Hayes Community Development Forum

WRITTEN REPRESENTATION

HIGHWAYS ENGLAND'S RESPONSE

1. For 'Deadline VI': Comments on submissions made for Deadline V, 8th January 2016 by Robin Brown on behalf of the Hayes Community Development Forum I refer to the Panel's Questions and the responses made.

Drawing title  
**VEGETATION CLEARANCE**  
**SHEET 30 OF 30**  
**REGULATION 4(2)(e)**  
**CRANFORD**

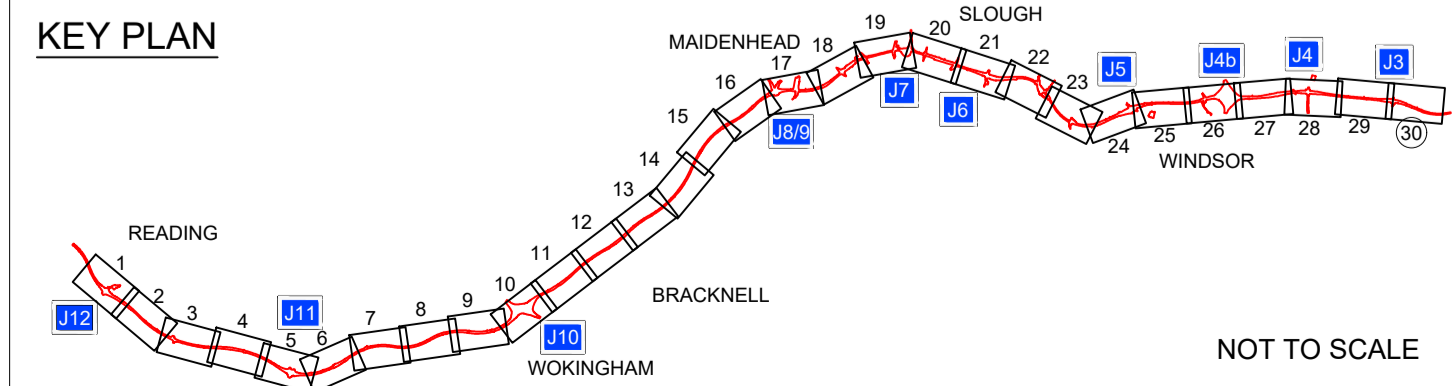
Great concern continues to be voiced at the lack of an effective acoustic and visual barrier alongside Cranford Park, particularly in the vicinity of the heritage assets.

Again, it is not understood why the proposed 3.5m high acoustic barrier (ref EM33) ends at the Park subway (circa 11220 chainage) and does not continue further east, albeit not necessarily at the same height. Previously it was assumed that there existed a circa 1.8m high acoustic barrier along the east bound carriageway and this informed the noise modelling. However, now a substantially higher barrier is proposed which seems to indicate that the noise climate from the scheme is predicted to be greater than could have been mitigated by the original 1.8m high barrier. If this is the case then the noise climate could be geographically more extensive and include homes in Cranford lying to the east of the Park's subway.

2.1. Highways England will provide a new 2m metre high noise barrier at this location under its commitment, secured under Requirement 22 in the draft Development Consent Order ("DCO"), that any existing barriers included as acoustic barriers in the noise assessment, and which turn out not to be acoustic barriers, will be replaced with acoustic barriers. With this new acoustic barrier in place, the noise reductions with the Scheme in operation will be an improvement on those shown in Sheet 15 of Drawing 12.4 of the ES (Application Document Reference 6-2, APP-265, APP-266, APP-267, and APP-268). Consequently, the setting of these heritage assets will be enhanced, in compliance with paragraphs 5.130 and 5.137 of the National Networks National Policy Statement ("NN NPS").

2.2. This area was included within the enhanced noise mitigation study. However, the assessment indicated that no additional barrier needed to be provided to the east of St. Dunstan's Subway, i.e. to the eastbound and westbound slip roads to junction 3. This is due to the fact there are no permanent residences in this area which would gain any benefit from an additional barrier. Furthermore, the noise level is forecast to reduce as a result of the Scheme. As the principal benefits of noise barriers relate to long term health issues (e.g. sleep disturbance) which are not applicable to effects on short term visitors, provision of additional noise barriers in this area is not considered to be justified or a good use of taxpayer's money.

- 2.6. As detailed above, a 2.0m noise barrier will be provided in the Cranford Park area which will also act as a visual barrier. Elsewhere, where no noise barrier is proposed, the latest visual assessment, which was submitted to the Examining Authority on 9 February 2016 (which takes account of the updated vegetation clearance submitted for the second hearing) considers a slight adverse effect at Opening Year 2022 on limited views at the north edge of the Park and a neutral effect by Design Year 2037. Therefore, no additional visual screening is required in this location.
